Subject: Gladwyn

Scales: 1:20 1:200 No: 2386/01/13

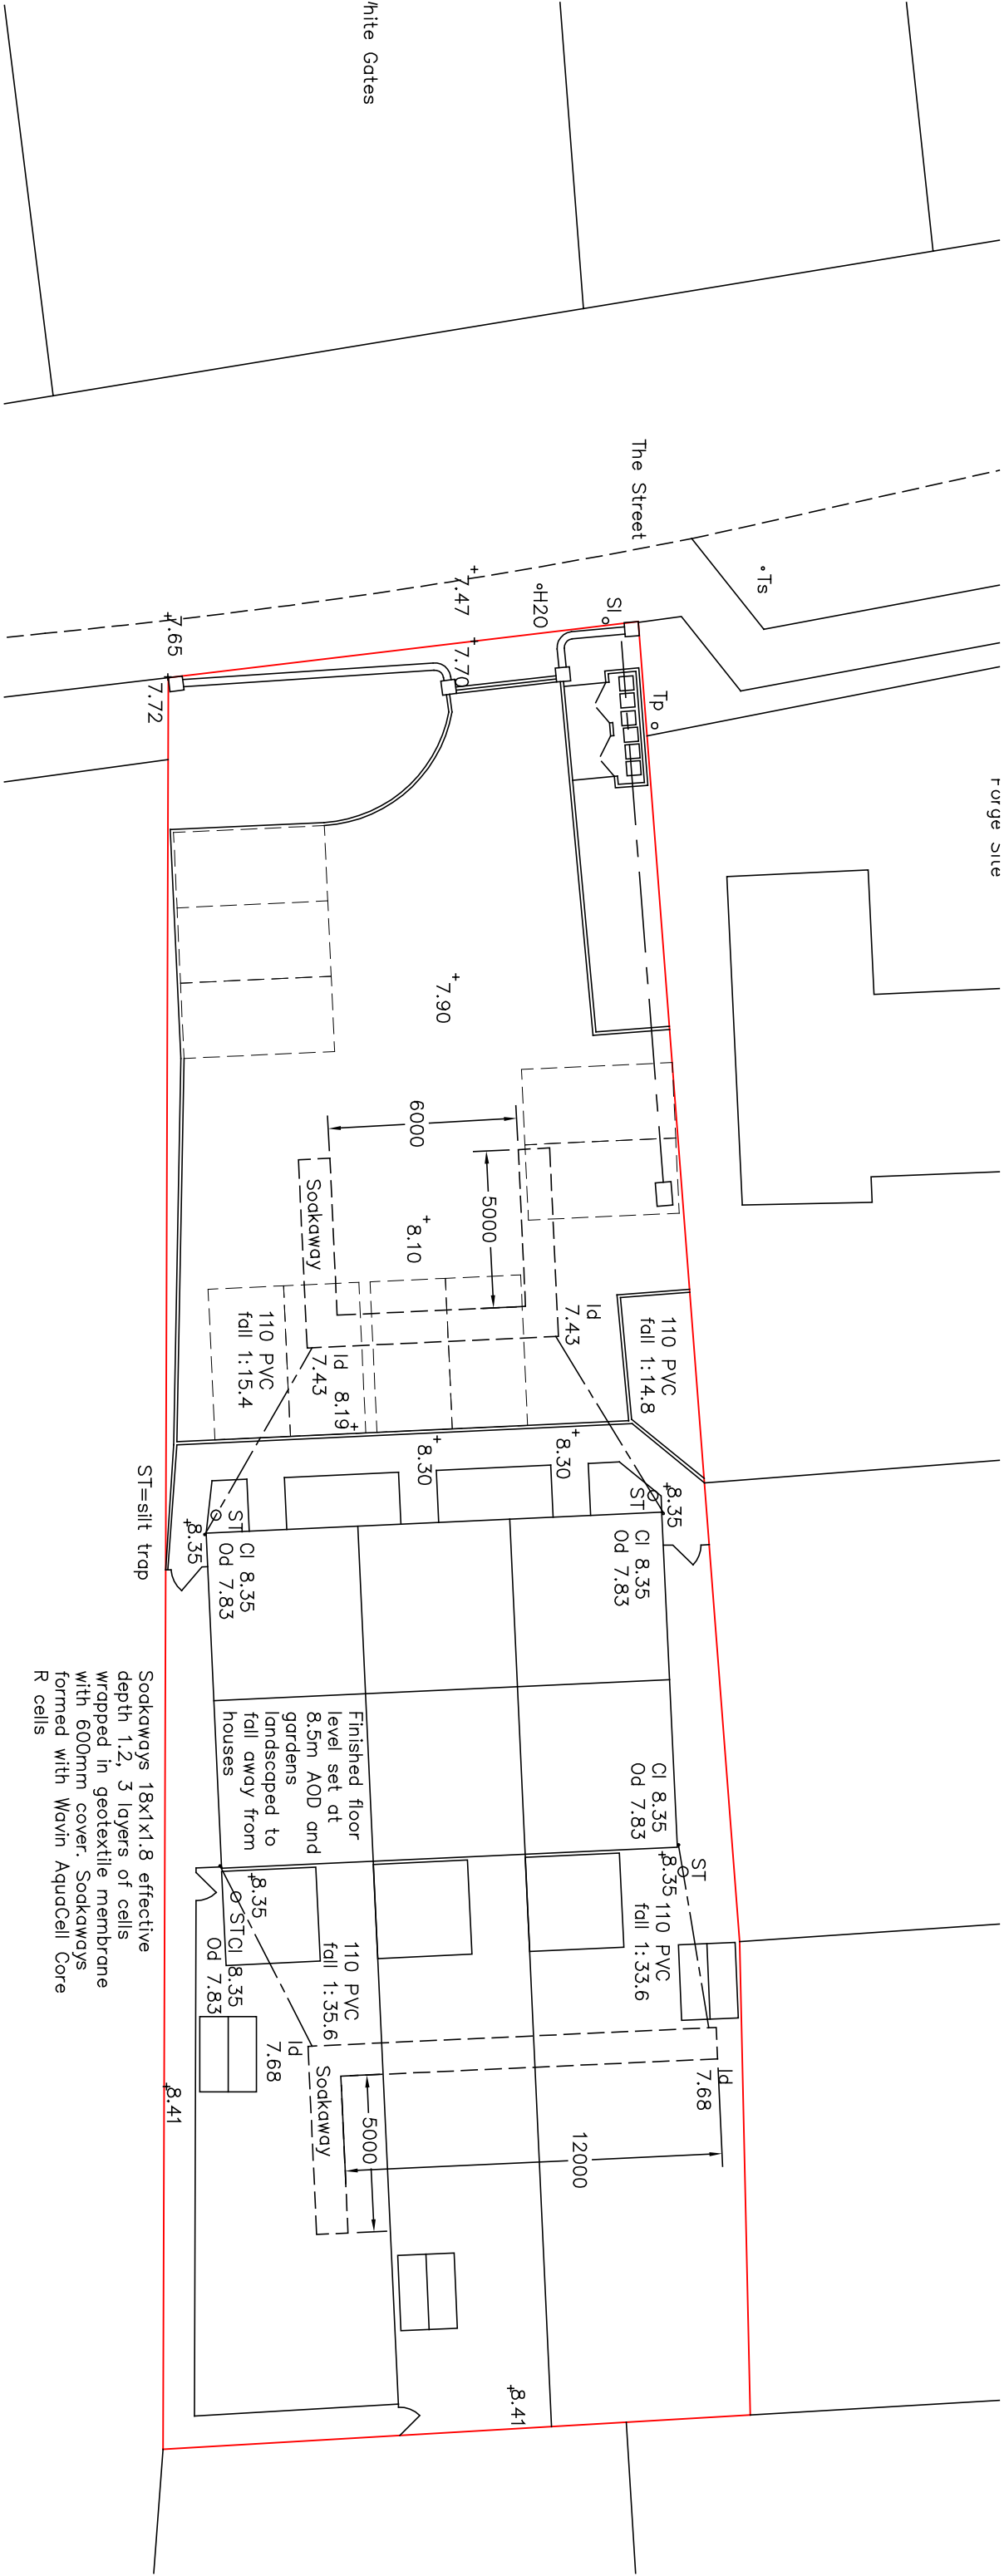
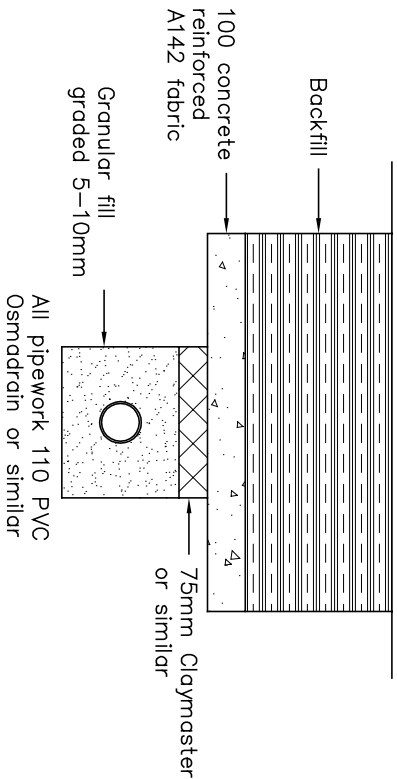
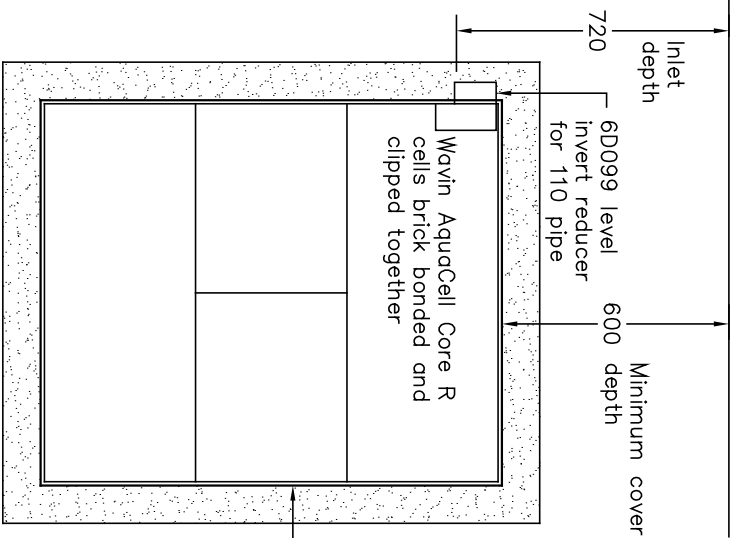
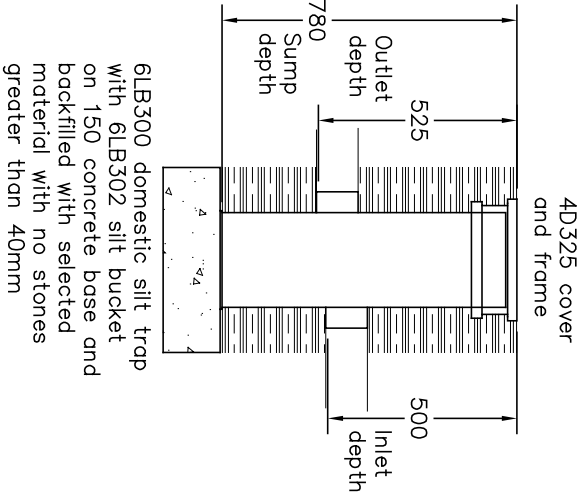
Almost all of my points have been covered off on this one. Unfortunately there are still issues regarding the soakaway and pipe work under the parking area. The drawing states that soakaways have a cover depth of 600mm, yet the west soakaway is laid under the car park. According to the BBA Certificate for the product (Table 9 page 8), the minimum cover depth under vehicular areas should be 700mm. We would also need to see a concrete bed and surround for the pipes under the parking area (Class Z). Once these issues have been rectified on the drawings I shall be happy to recommend discharge of conditions.
